# ENG-SF20015-R3-TIS-redlines.pdf Markup Summary

Figure 2  
 LSC # 074230

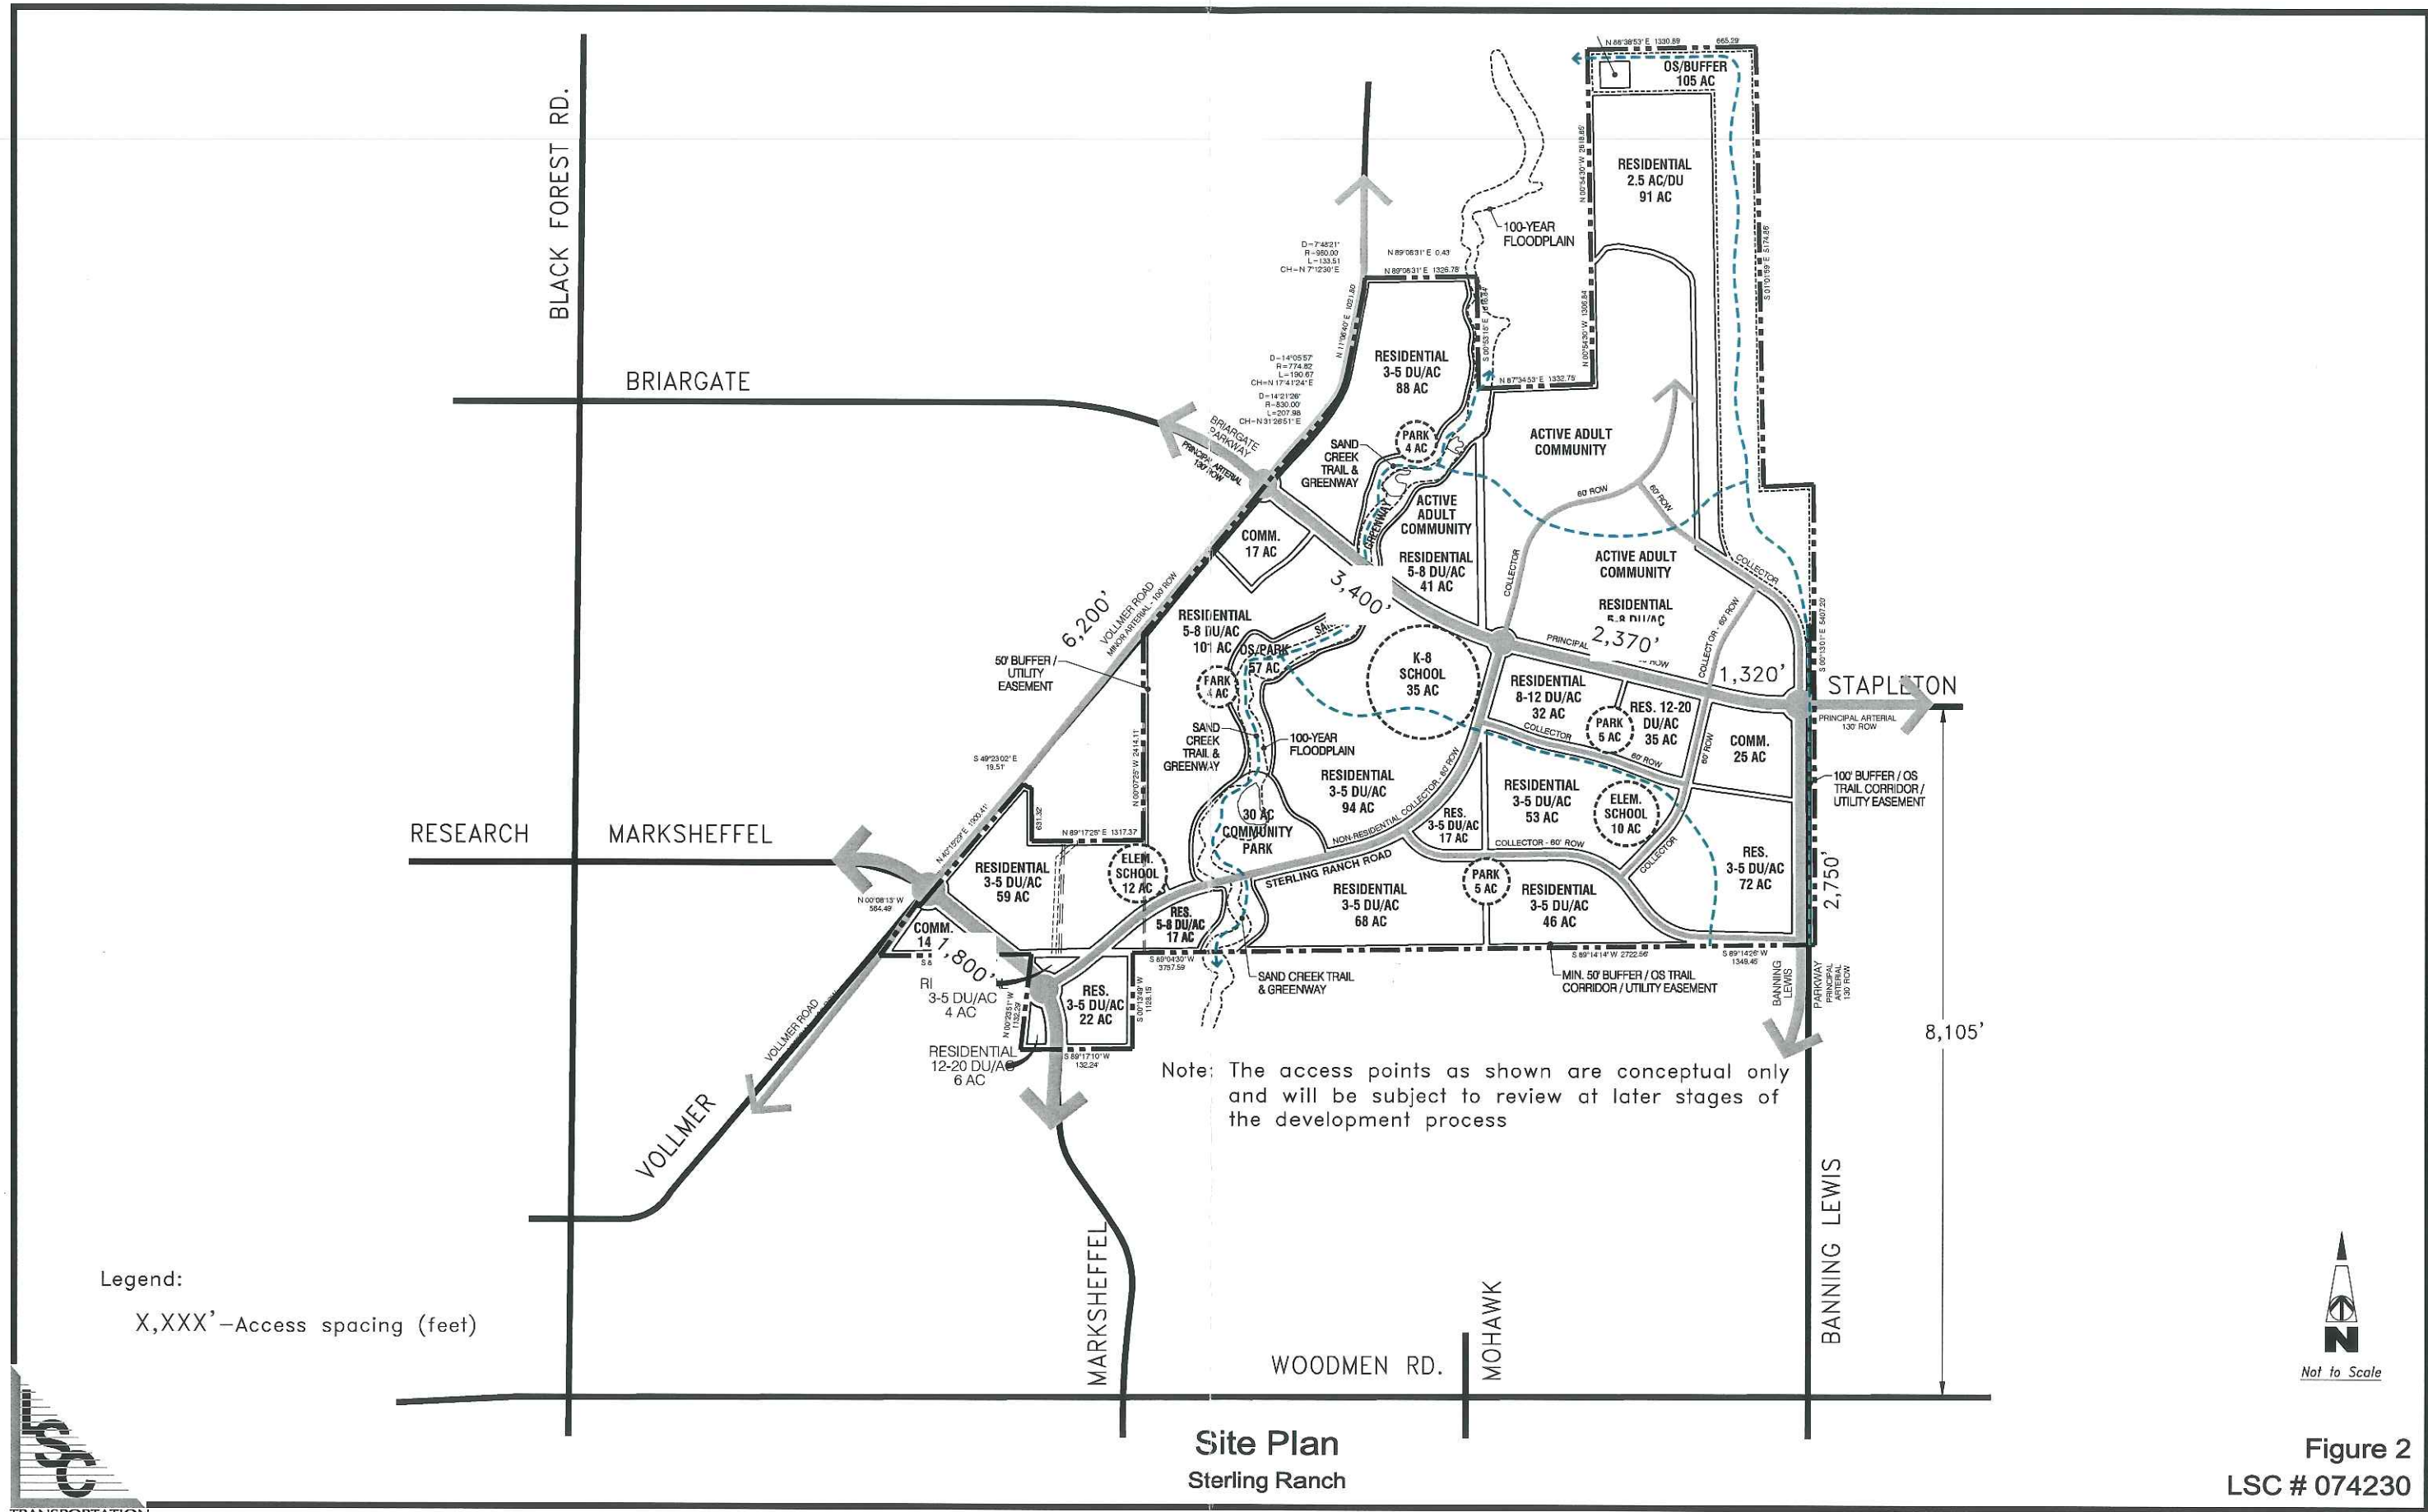
Replace Figure 2

Replace Figure 2

[Duplicate of next figure?](#)

Duplicate of next figure?
